Ask for: Sharon Horner
Telephone: 01832 742001
Planning Services
Our Ref: NE/21/01765/FUL
Your Ref: PP-10448426
Date: 8 December 2021

**Proposal: Orangerie extension at East Wing Clopton Hall Main Street
Clopton Kettering Northamptonshire NN14 3DZ.**

drawing no.	CO.EW.P04	A
drawn	checked	
scale	As shown @ A2	date

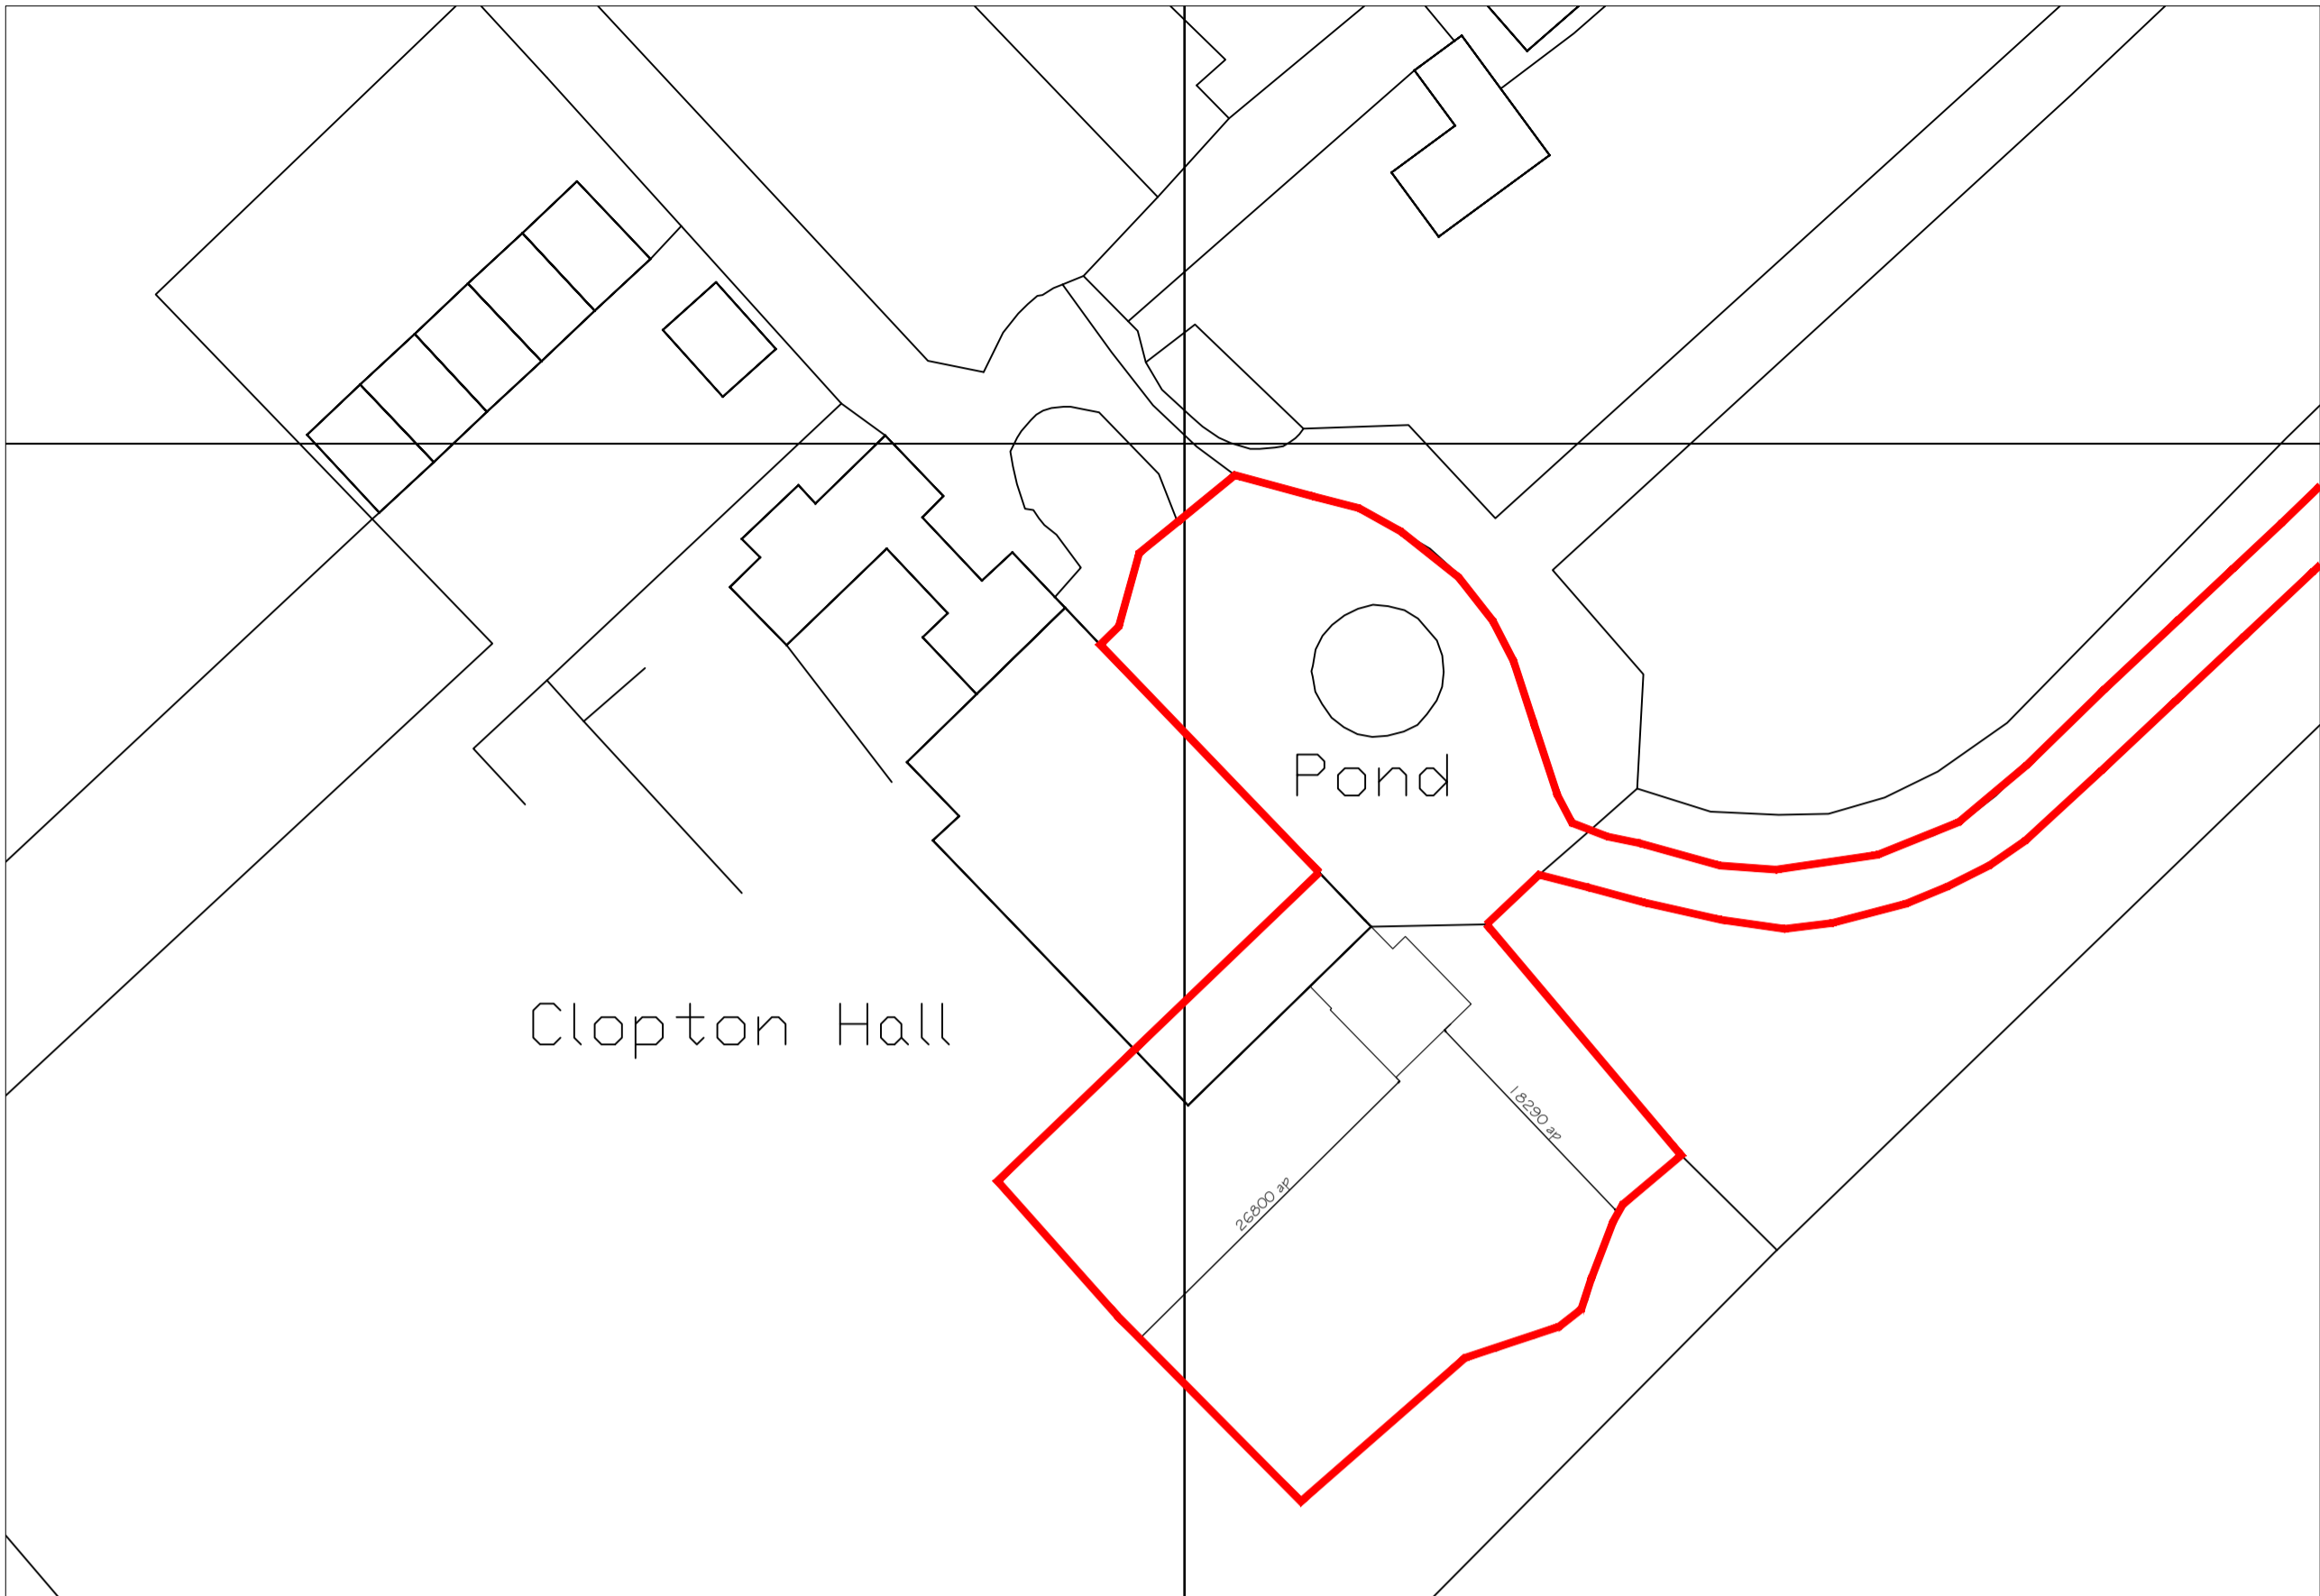
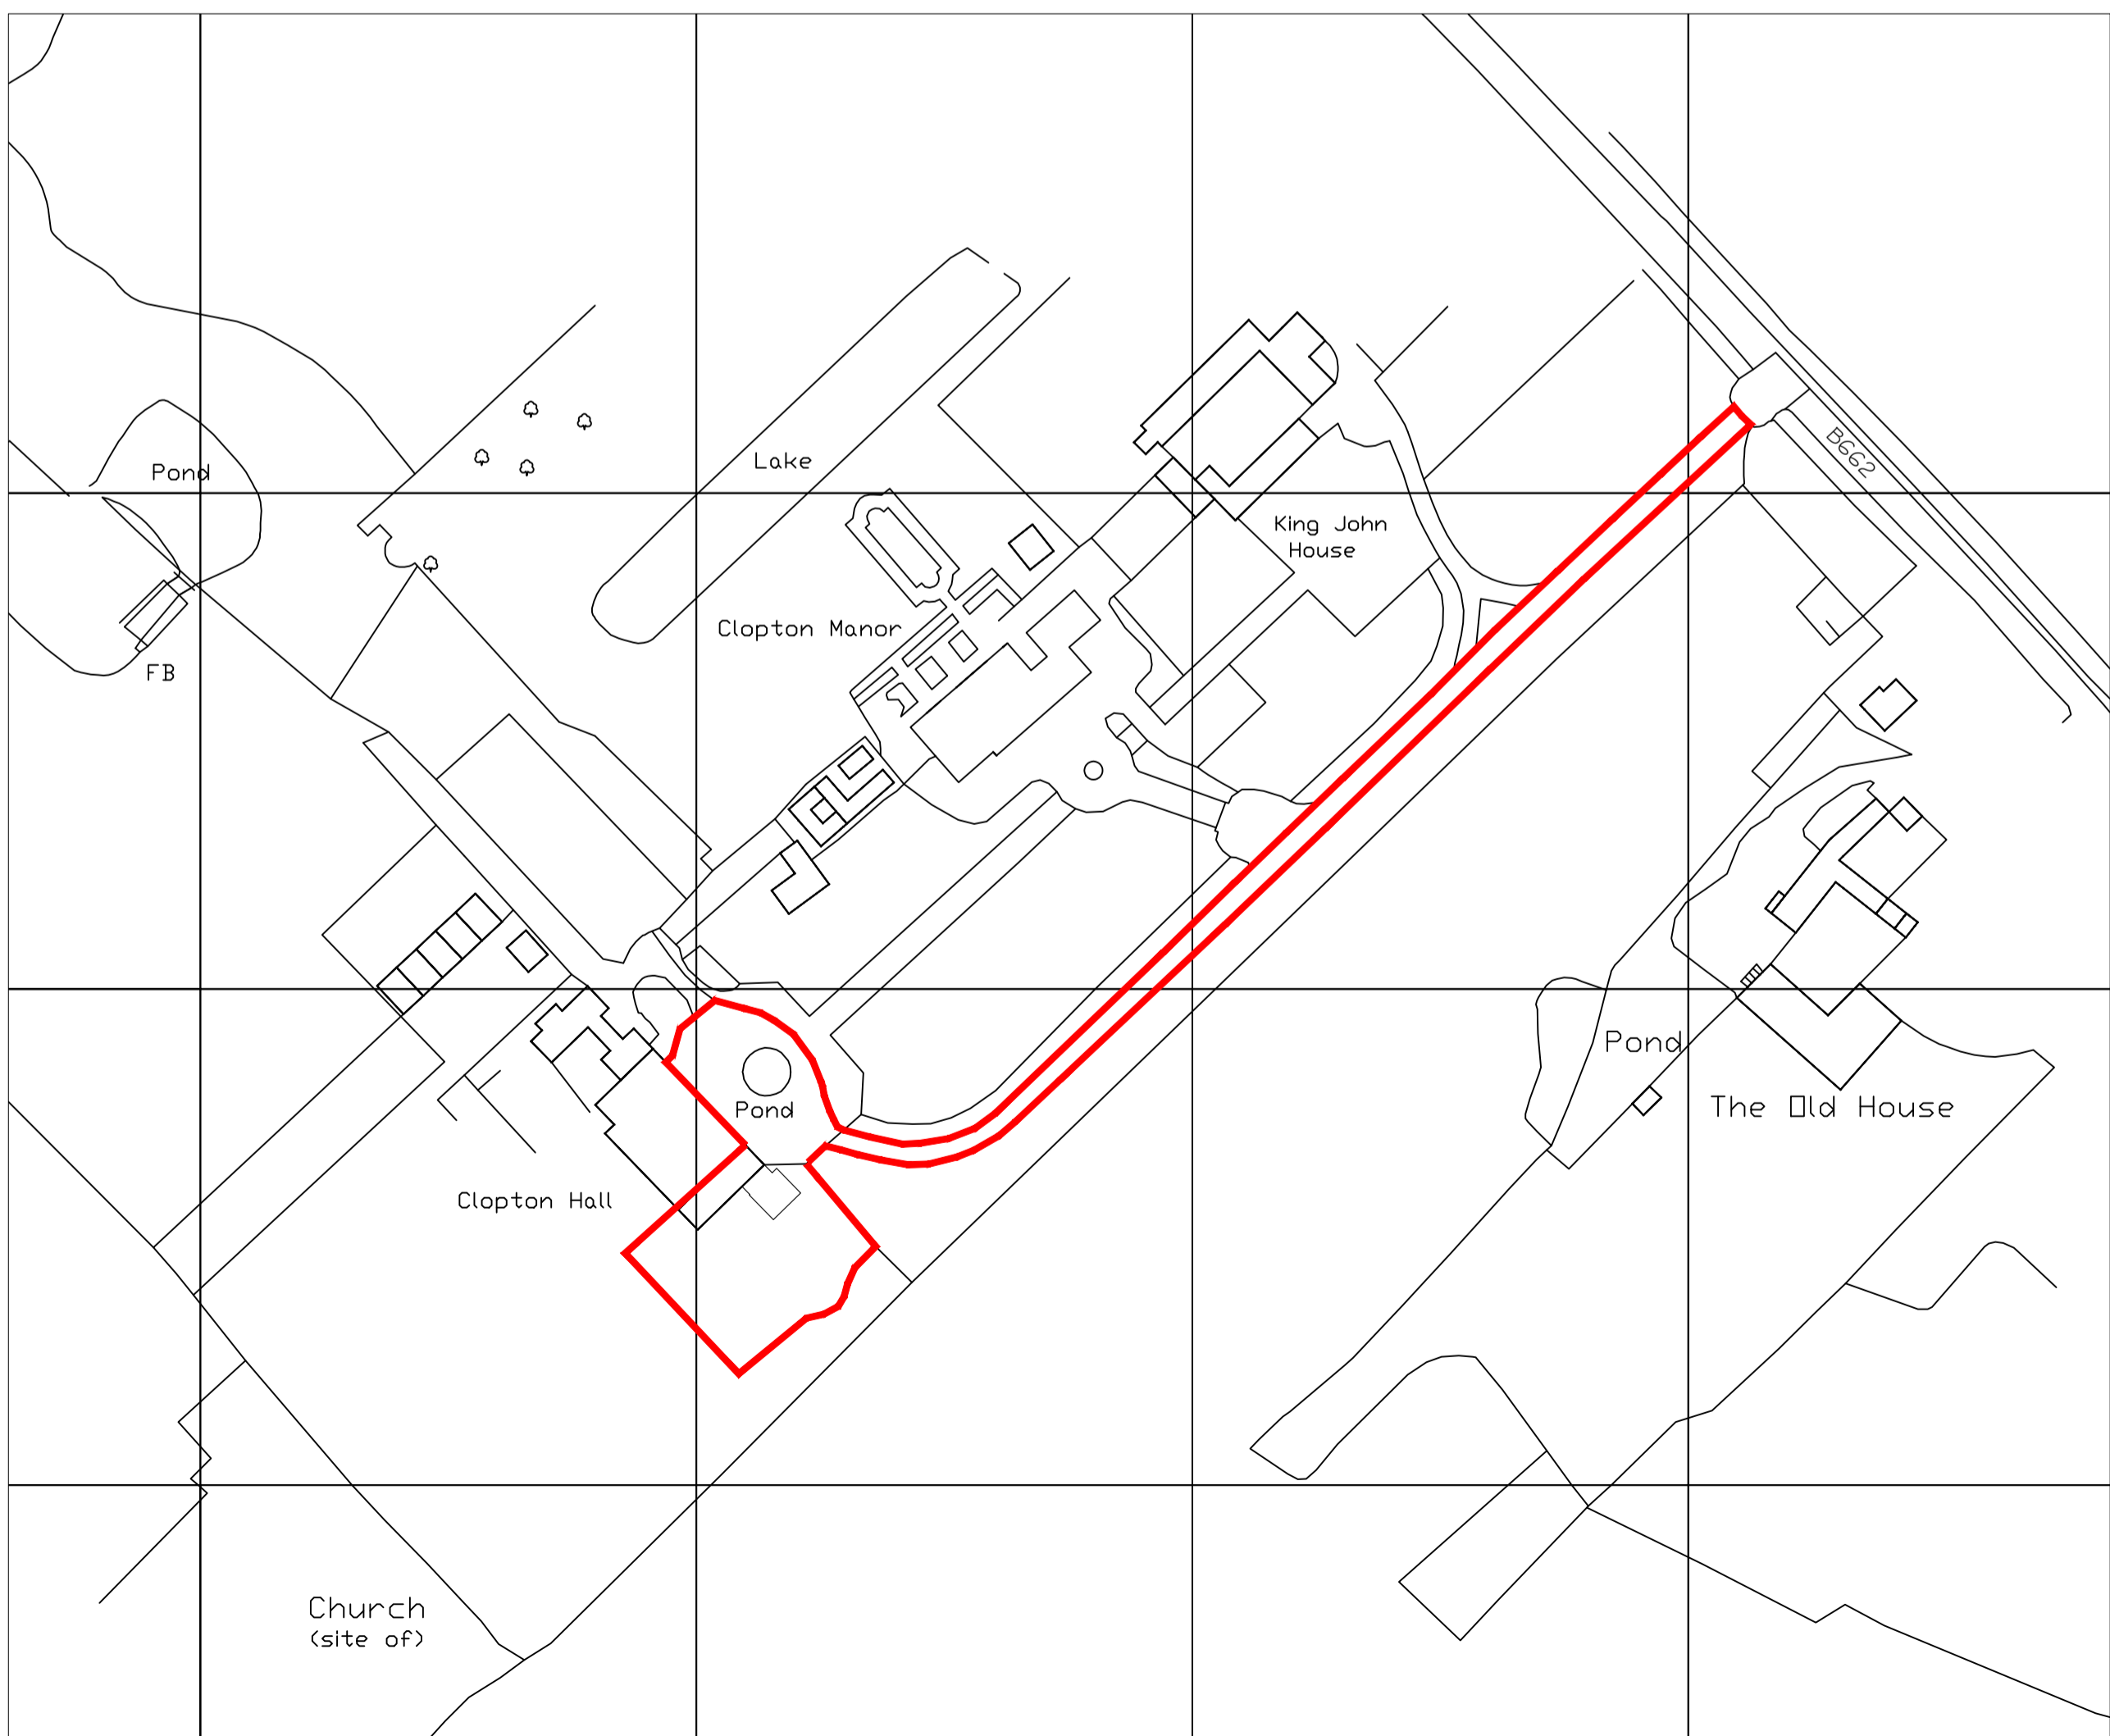
Please provide amended drawings including all relevant dimensions of the proposal:

- Dimensions for the site layout/block plan. The plan must be to a scale appropriate to the site and development (normally 1:500 or 1:200), showing distances from the site boundary of the proposed works (Drawing No. CO.EW.P04).

This will allow the officer to assess any potential visual impact of the scheme.
